From: Simon Davis
Sent: 20 September 2018 09:08
To: [REDACTED]
Subject: RE: P/83/18/DOC - FTAO Mr S Davis

Engineers Comments Regarding Condition 4- Surface Water Drainage

APPLICATION NO: P/83/18/DOC

Description of Works: Approval of details reserved by condition imposed under P/4/18/PL relating to conditions 4-surface water drainage & 5-colour schedule for materials & finishes.

SOAKAWAY TEST RESULTS & SOILS INFILTRATION RATE

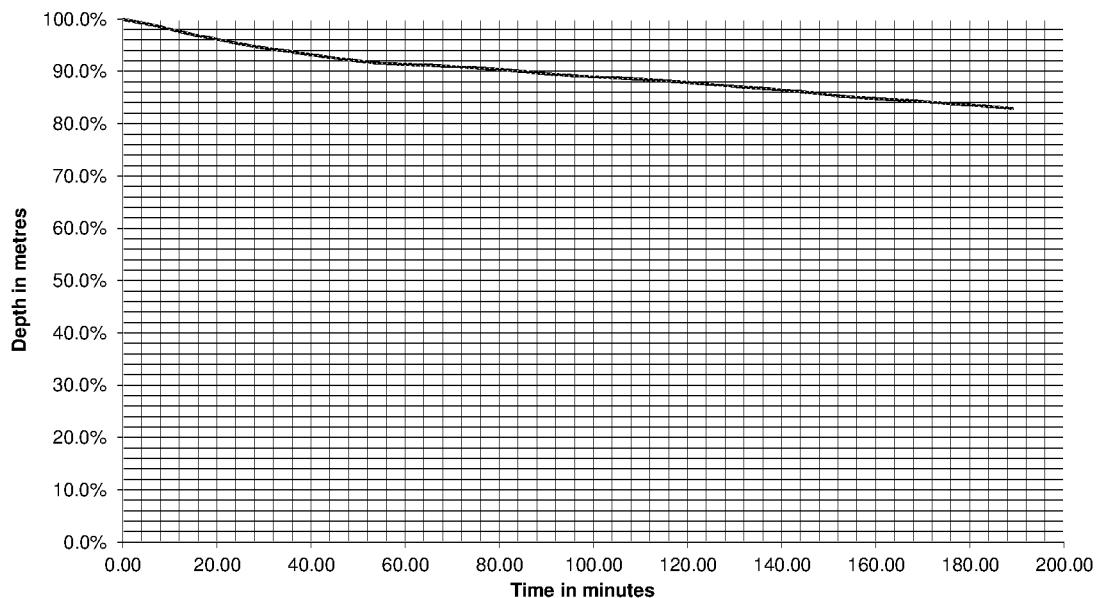
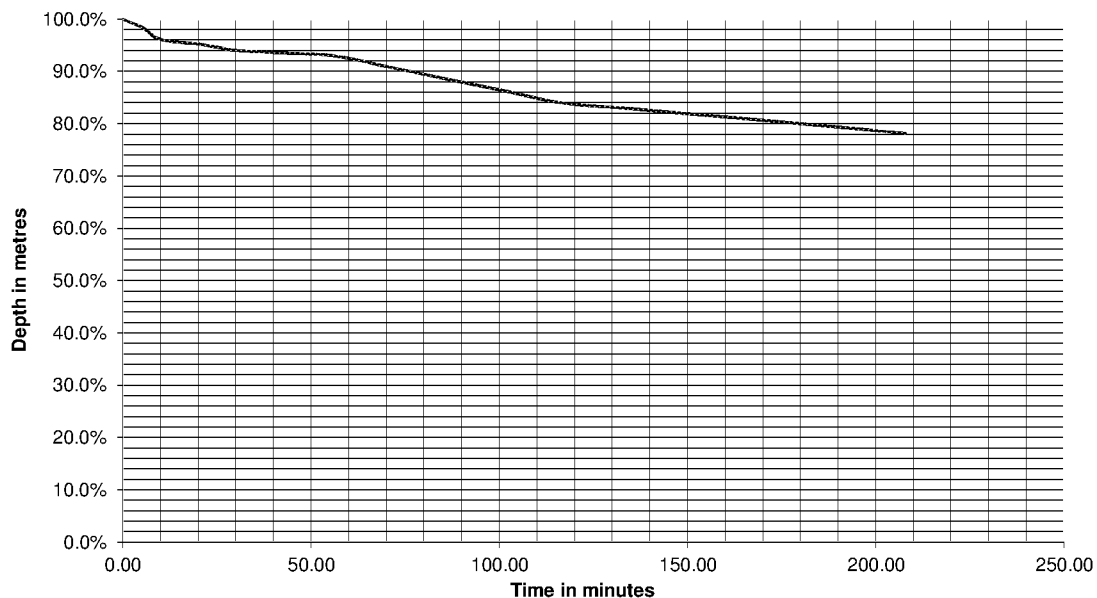
Groundwater monitoring results and infiltration testing results were provided. Maximum recorded groundwater levels were found to be m. Infiltration rates provided were low, $\times 10^{-6}$, however the percolation tests were completed at 2m depth, i.e. into the groundwater which was recorded as being at 1.35 mbgl.

The overlying strata are also of a more suitable type for infiltration. Shallow infiltration tests need to be completed at 600mm depth.
